From: P WARE [REDACTED]
Sent: 03 July 2018 10:04
To: Richard Castro-Parker
Subject: Objection to Proposed Planning Application - AW/129/18/HH - 20 Aldwick Gardens

**OBJECTION TO PLANNING PERMISSION – 20 ALDWICK GARDENS
APPLICATION: AW/129/18/HH**

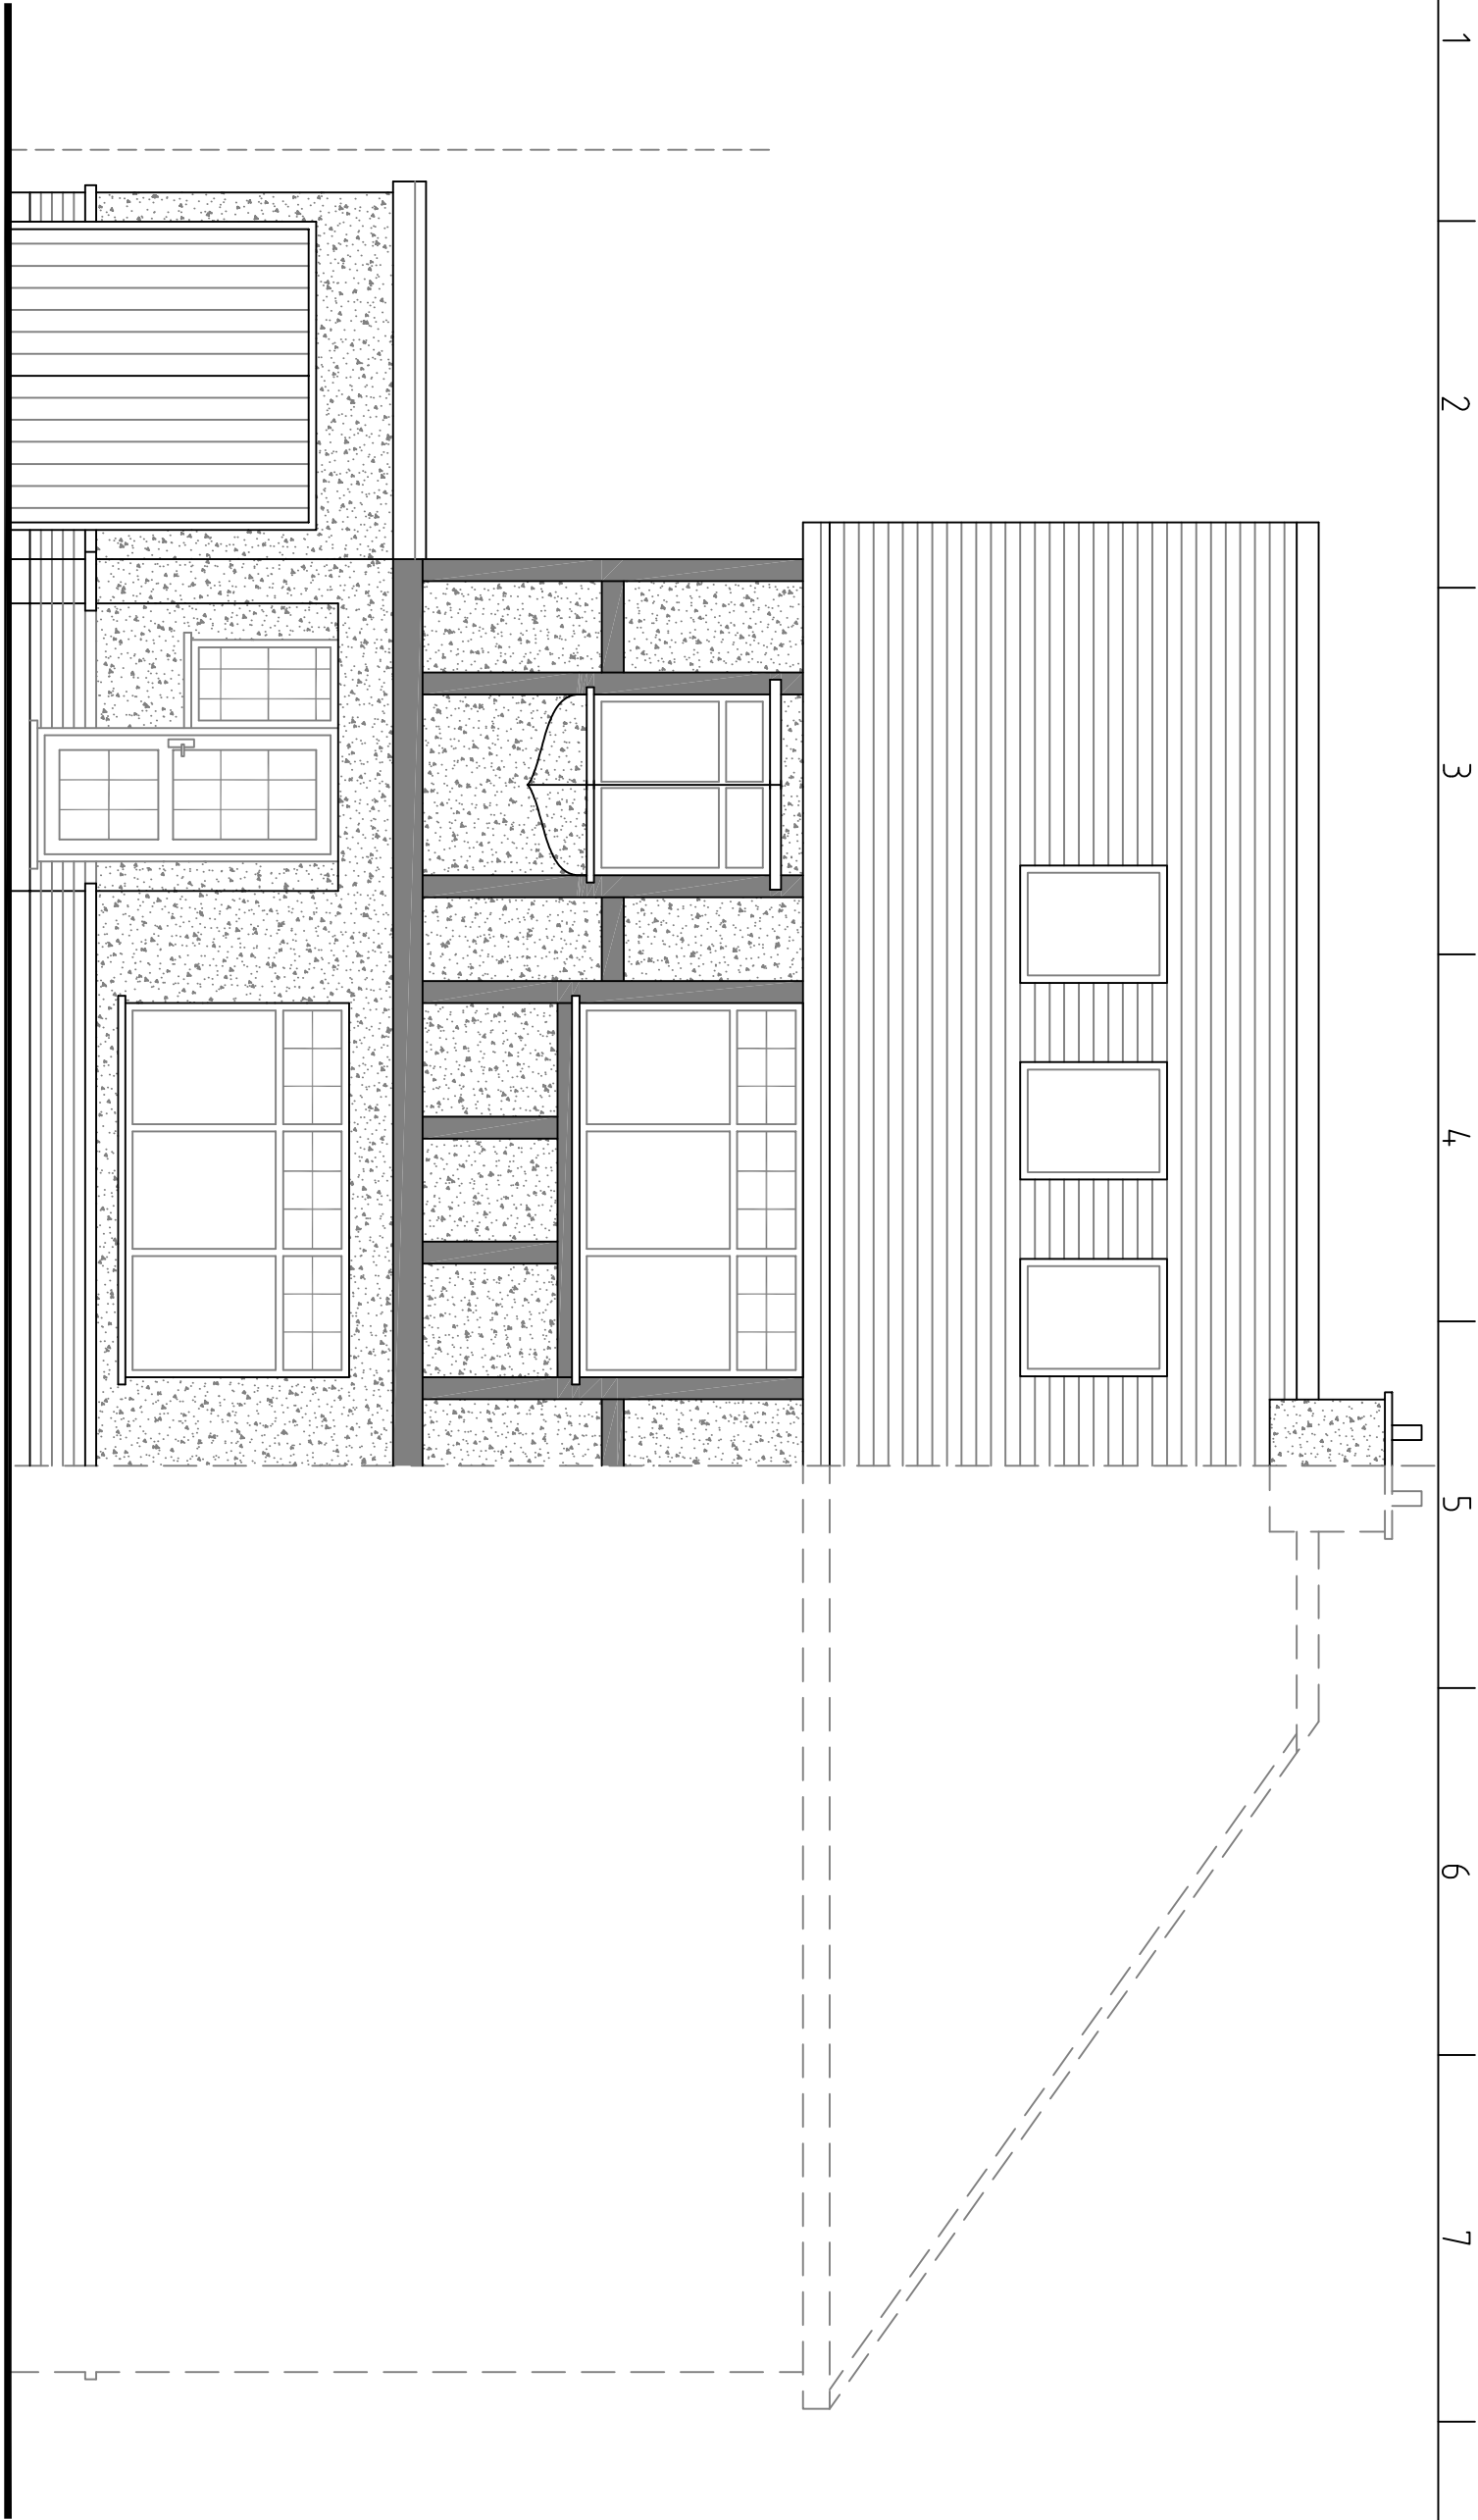
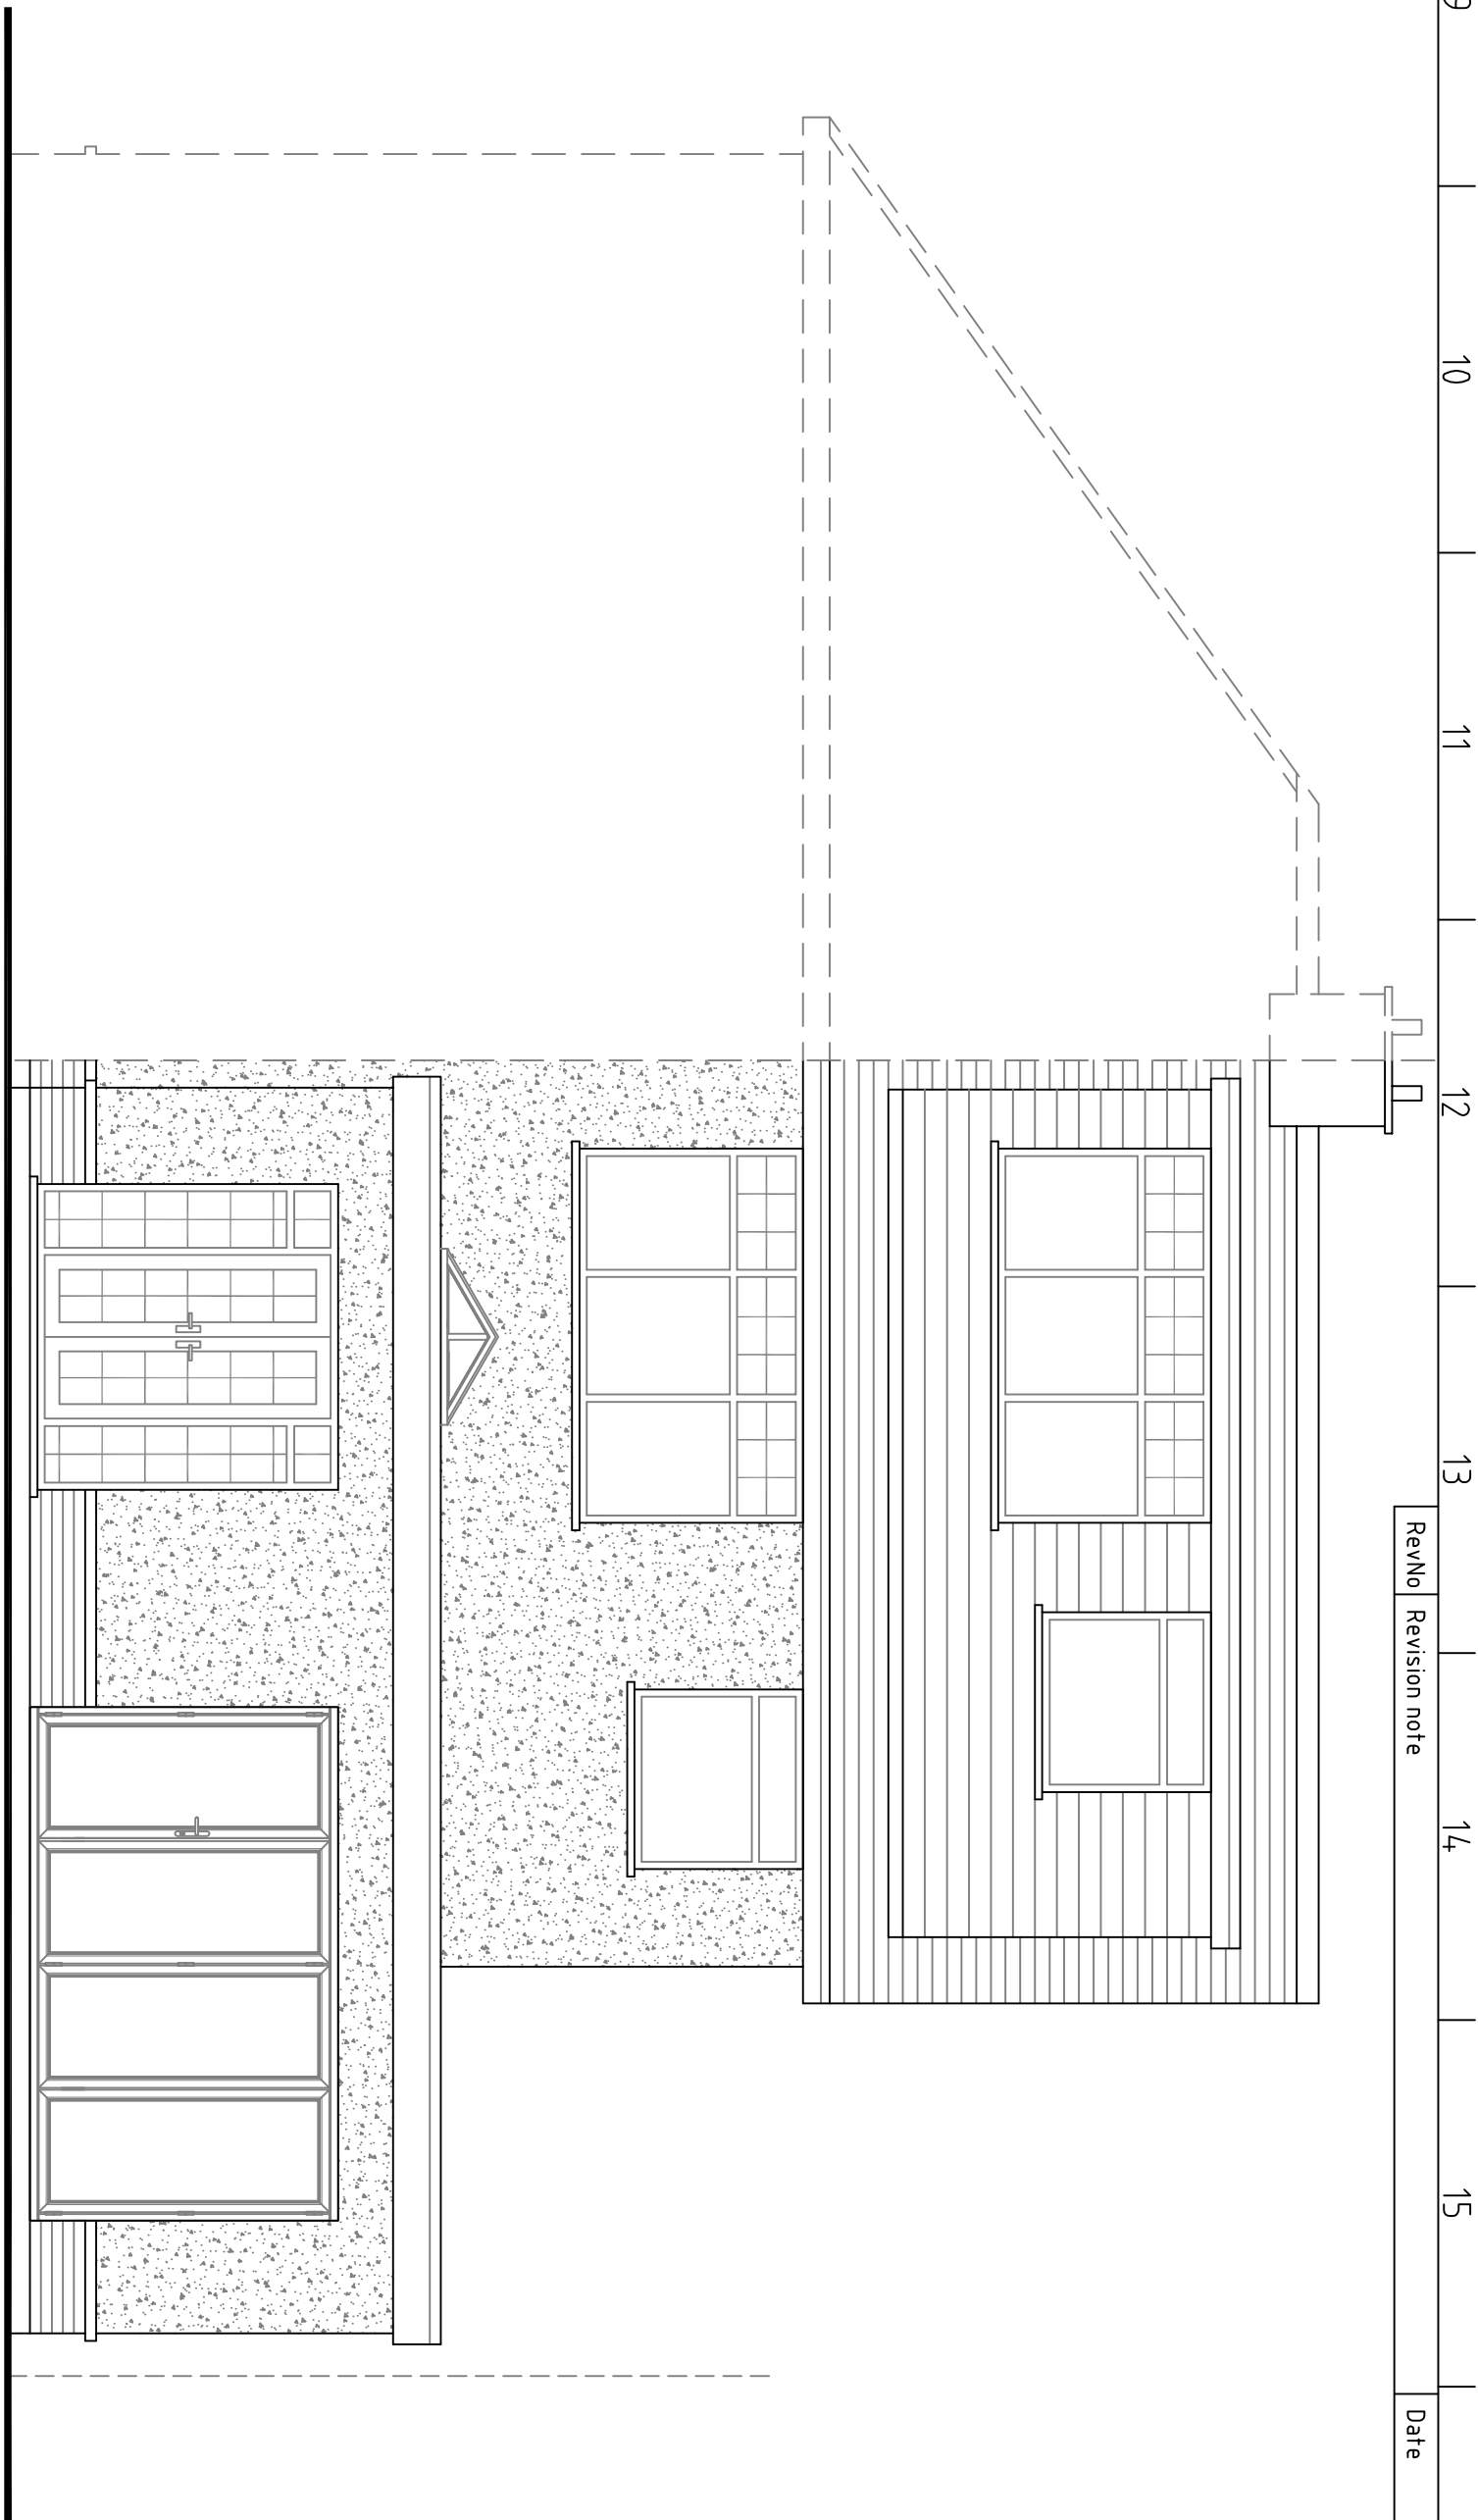
The house is at present a fairly attractive semi-detached with a standard pitched tiled roof. The proposed loft conversion will effectively make it a 3-story building as the plans show a squared off box type roof structure which looks as if it overhangs the side of the building. This proposed new roof in our opinion is completely out of character to the type of roof that exists on properties in this road, namely pitched.

As owners of the bungalow next door (no 22), the new construction will tower over our home and garden, invading our privacy and also restricting sunlight at times of the year.
